RESPONSE TO PCD COMMENTS
WALDEN PRESERVE 2 – AMENDED PUD DEVELOPMENT PLAN APPLICATION
PUD-18-007
May 20, 2019

SHEET 1 OF 6

Sheet number
1 OF SIX

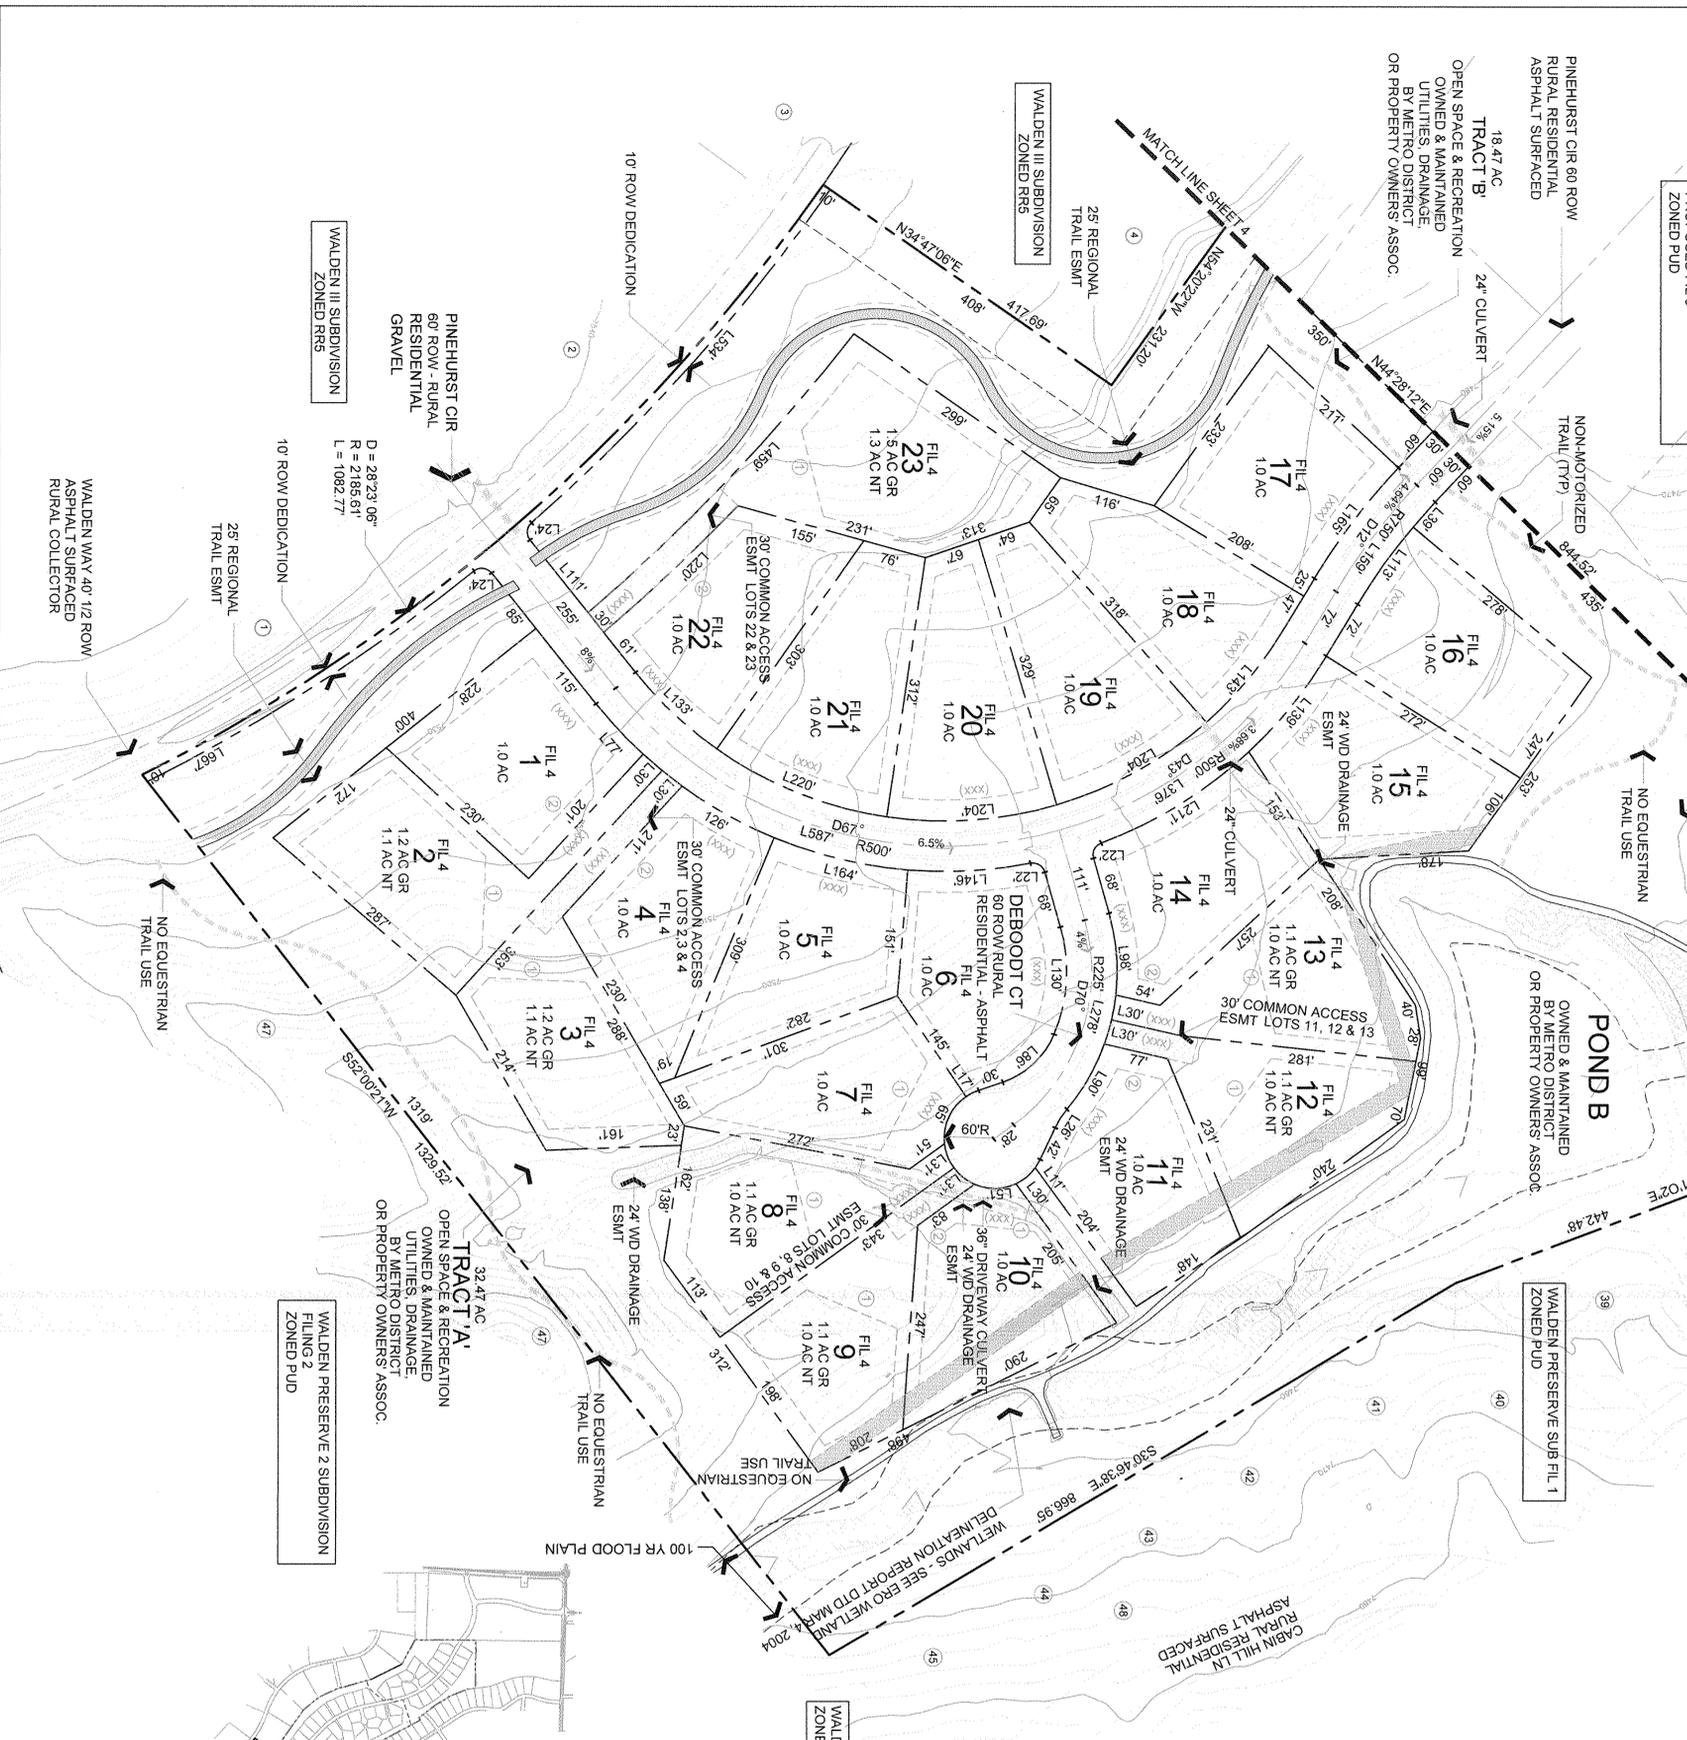
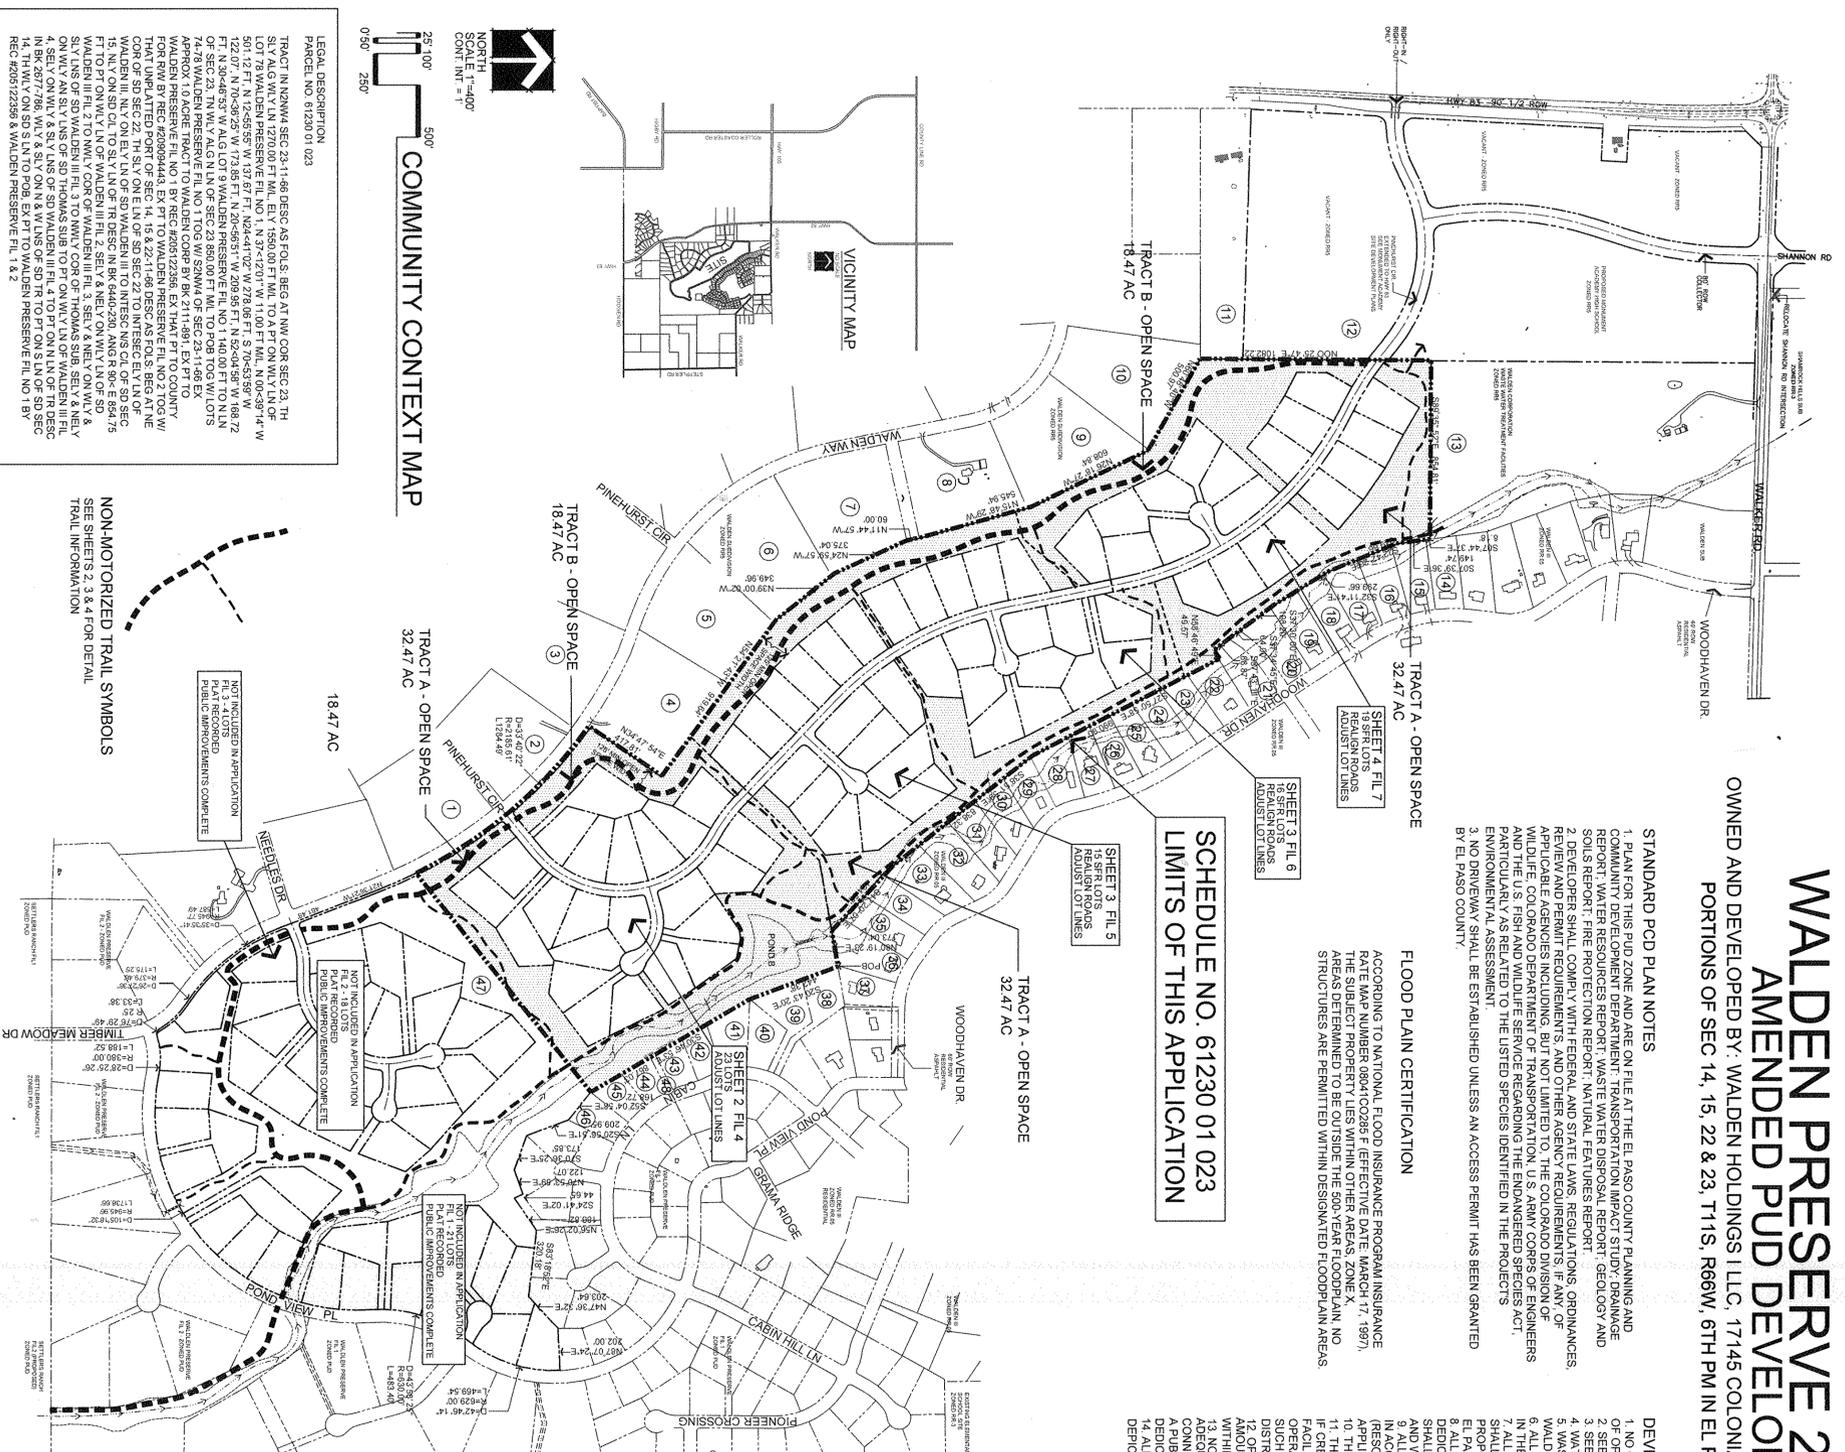
1. Add note on “Permitted & Accessory Uses”.
2. Revise “Standard PCD Plan Notes” title.
3. Add proposed and existing trails to Community Context Map. Add Trail Symbols legend with note referencing trail detail information on Sheets 2, 3 & 4.
4. Revise PCD Director signature text.
